Ecology response

**From:** Jonathan Best <Jonathan.Best@arun.gov.uk>  
**Sent:** 30 April 2025 16:11  
**To:** Planning.Responses <Planning.Responses@arun.gov.uk>  
**Cc:** Emma Sheppard <Emma.Sheppard@arun.gov.uk>  
**Subject:** BE/16/25/RES

Land at Oldlands Farm Newlands Road Bognor Regis PO22 9NN.

Recommendation: Refuse due to failure to meet the recommendations of the Ecological Impact Assessment (The Ecology Co-op, November 2022) for bats, birds and reptiles.

DRAWING TITLE
**DETAILED PLANTING PLAN
(Sheet 1 of 2)**

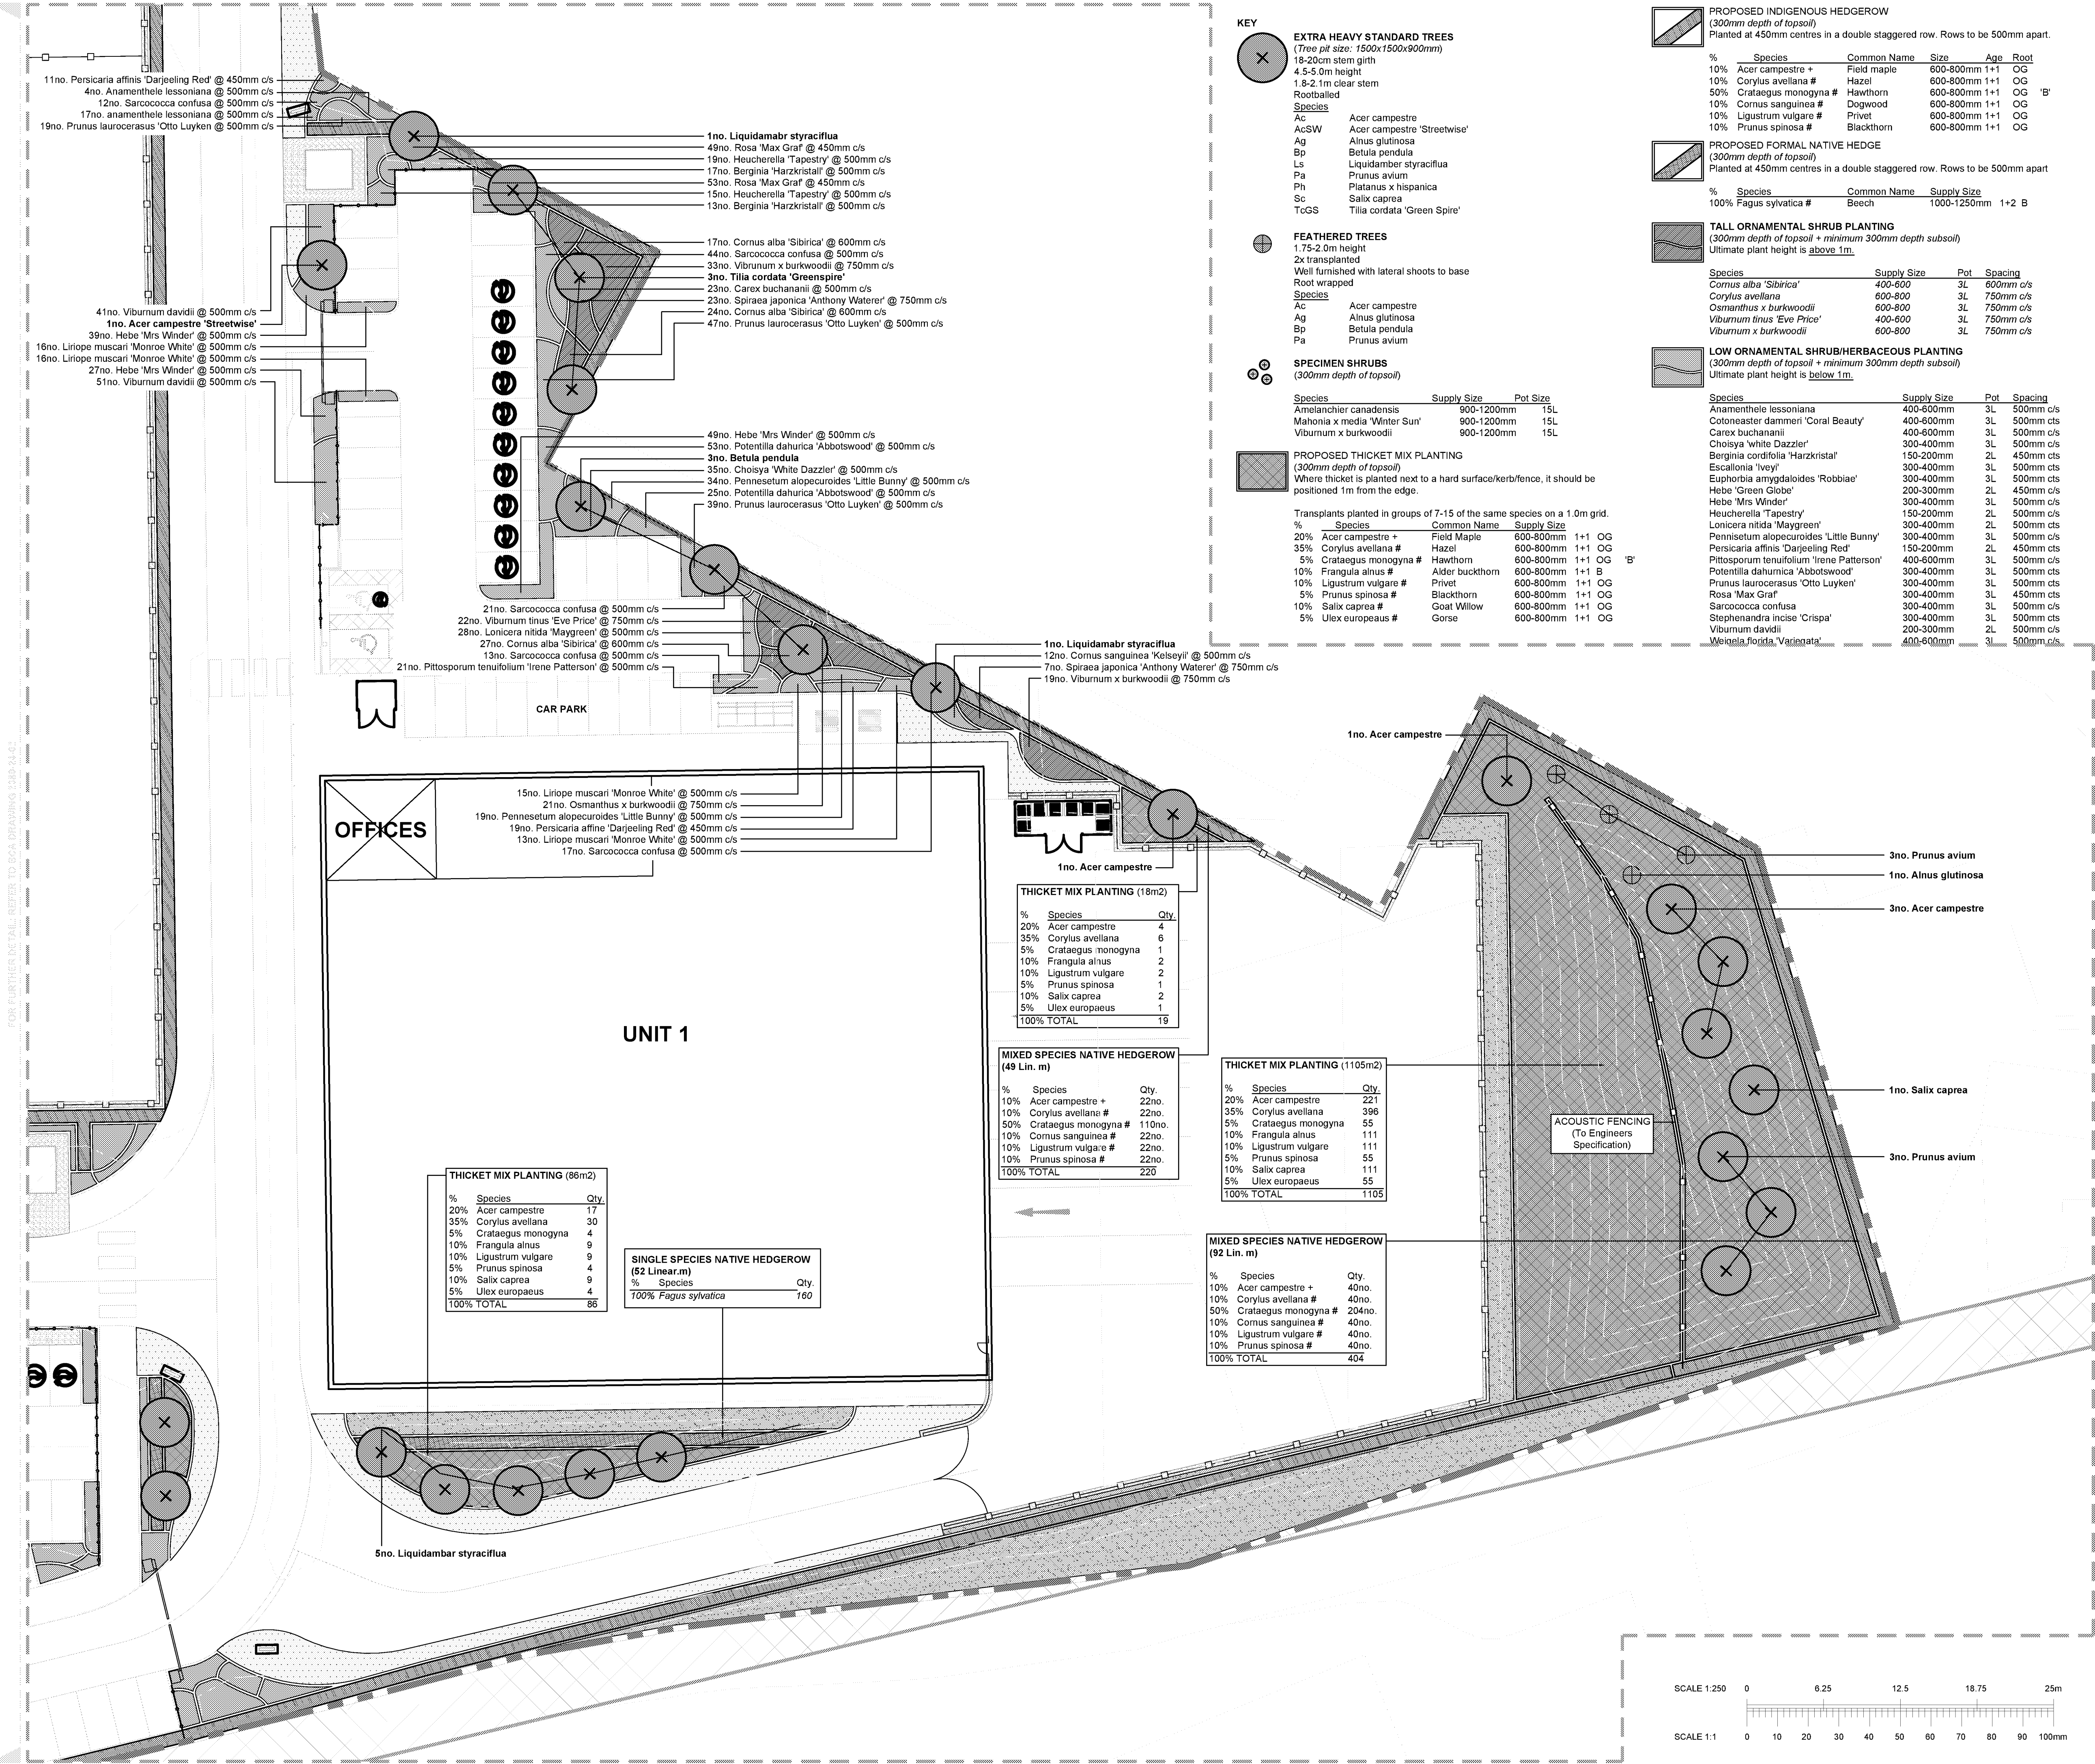
Because of the hedges shown on the plans, access for maintenance of the grass areas require review as it looks as if it would be very difficult to maintain grass areas on the southern end of the site without breaking through a hedge.

Ecological Enhancement Plan

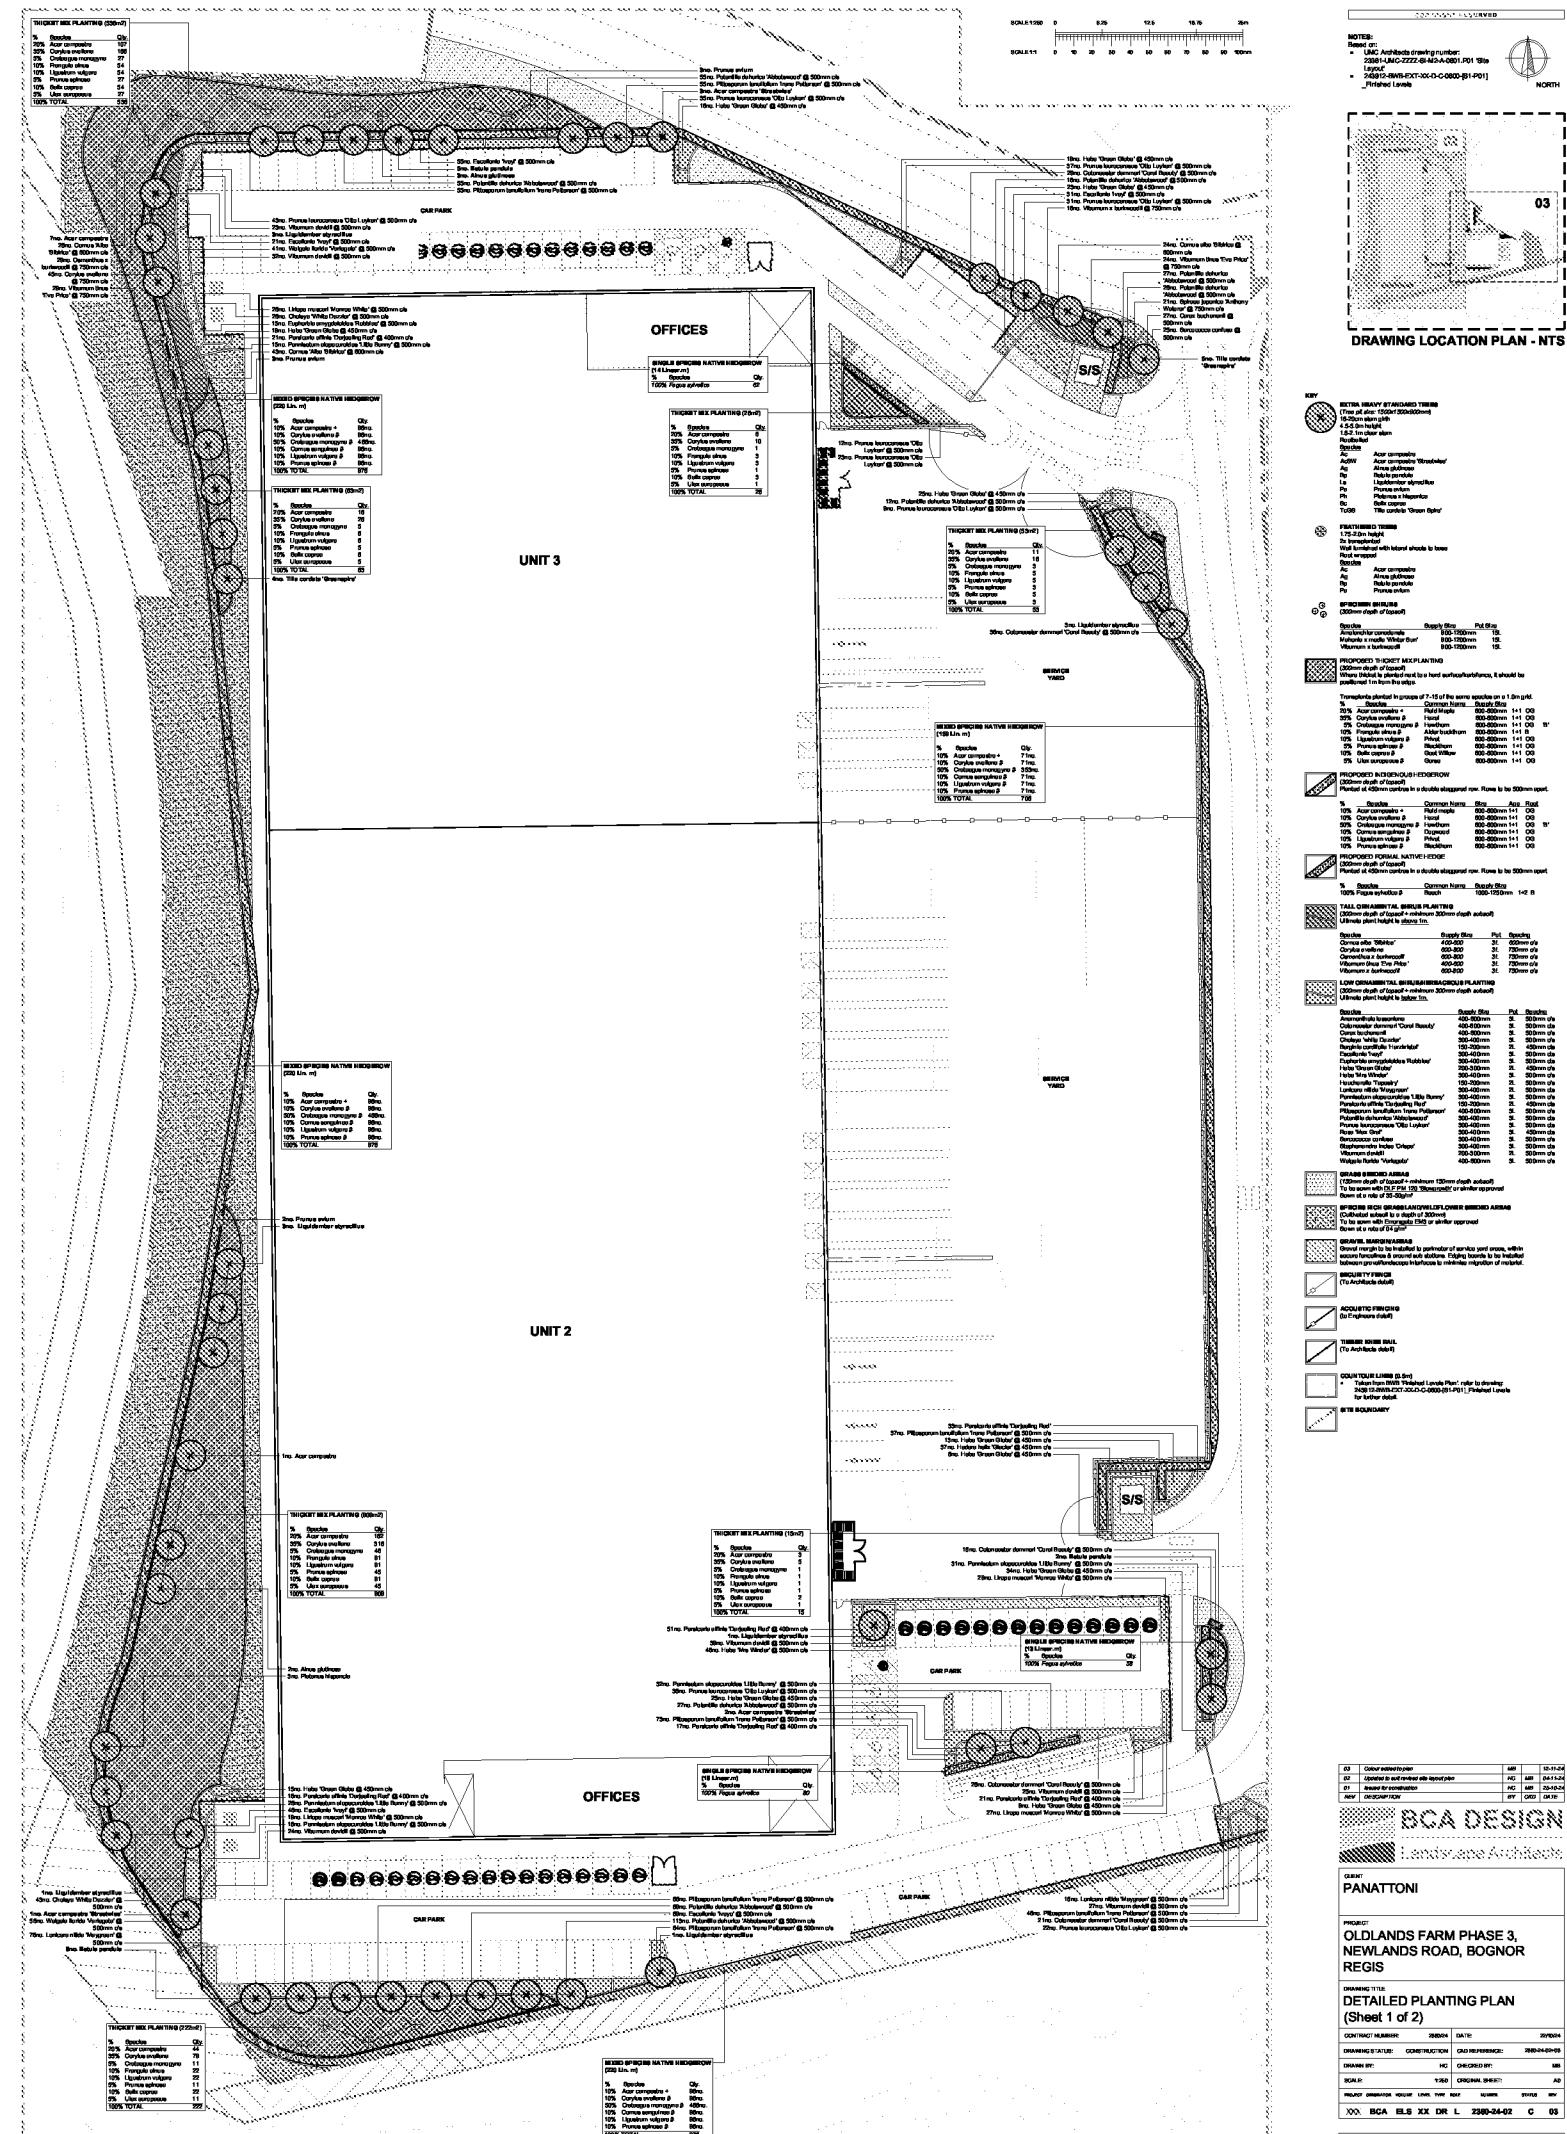
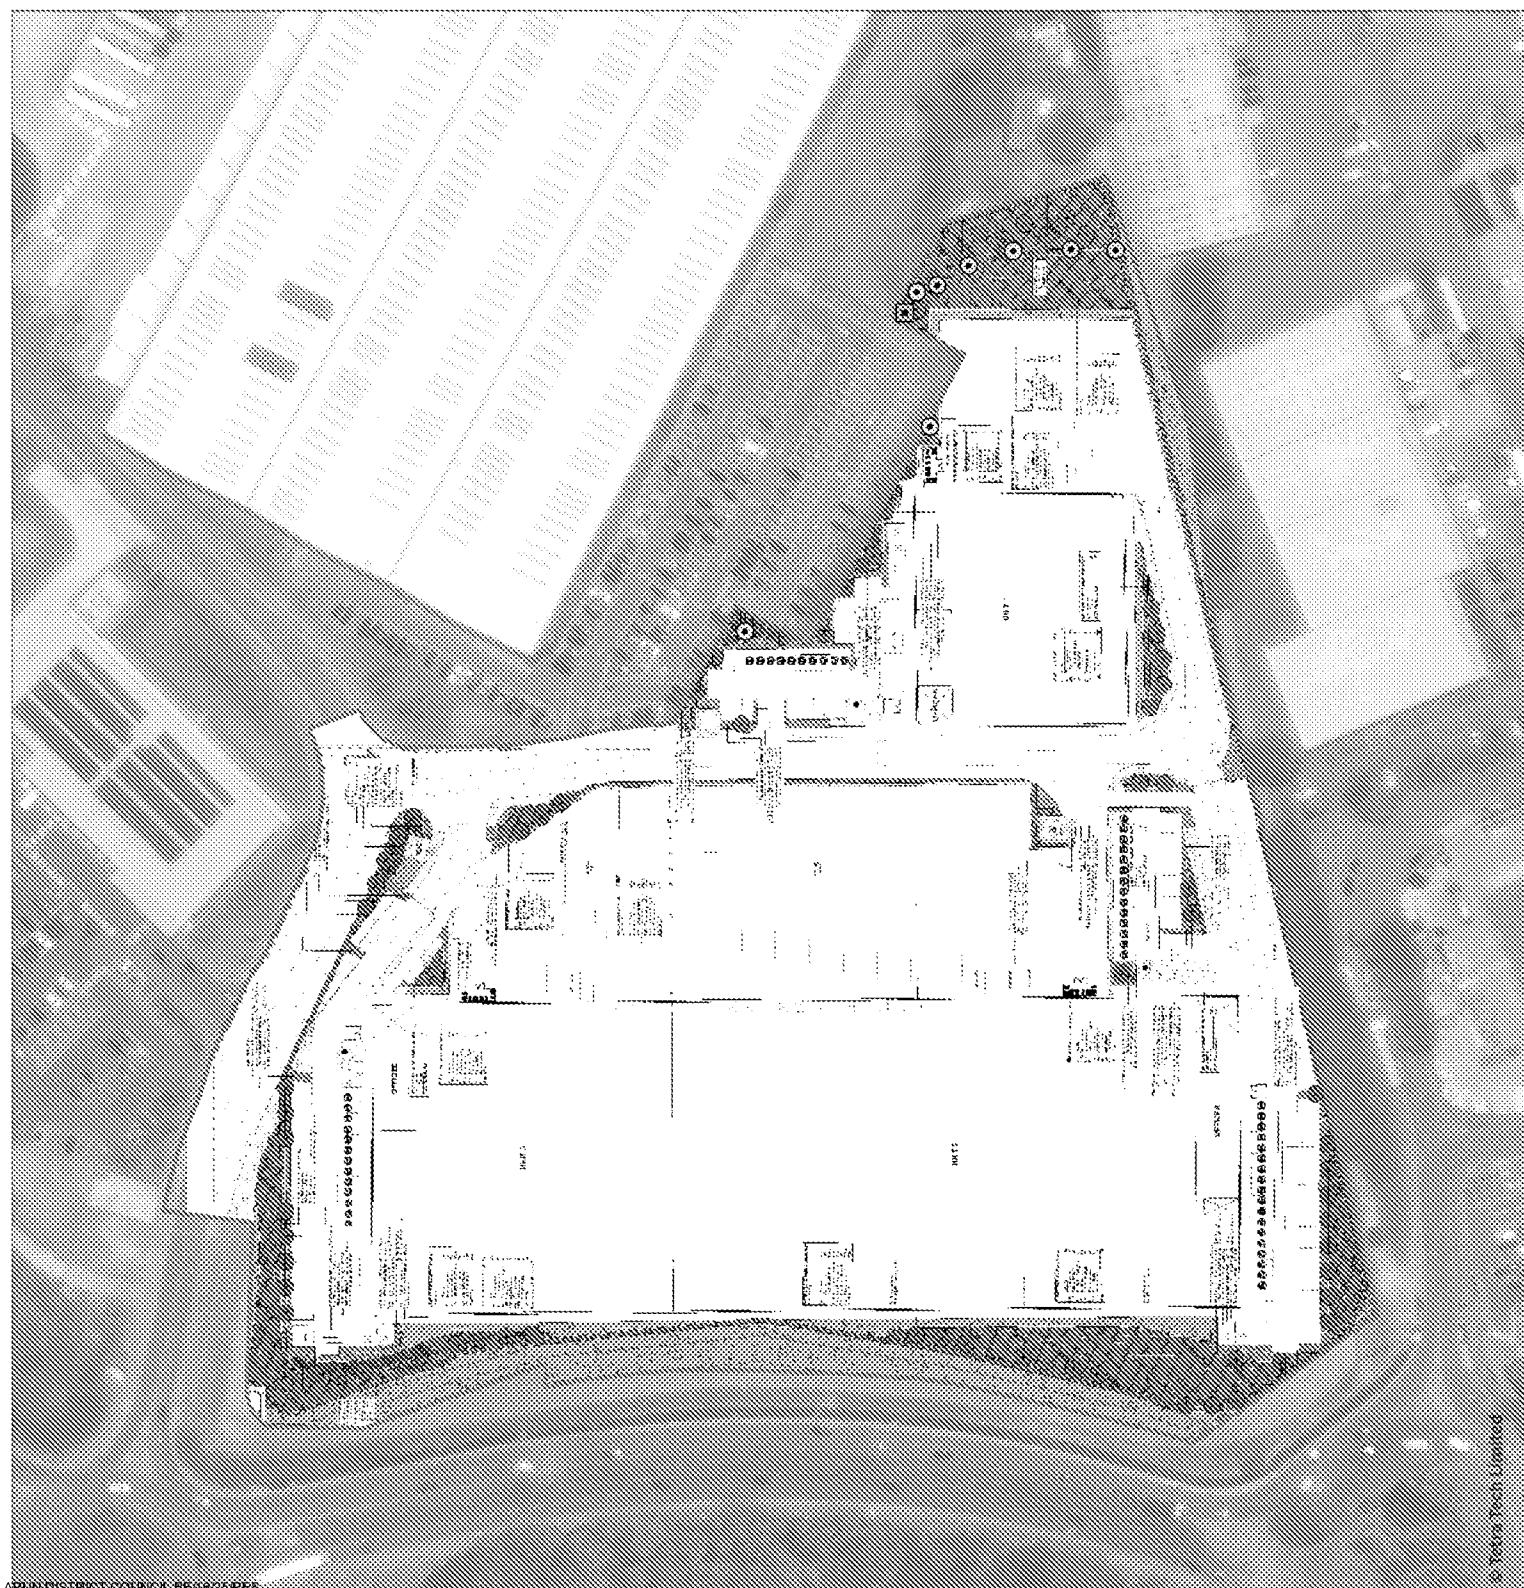
No wall mounted cavity bat boxes and only 3 tree bat boxes are shown on the plans. This falls short of the requirements.

Only 4 General purpose nest boxes are shown in the Biodiversity Enhancement Strategy February 2025. This falls short of the requirements.
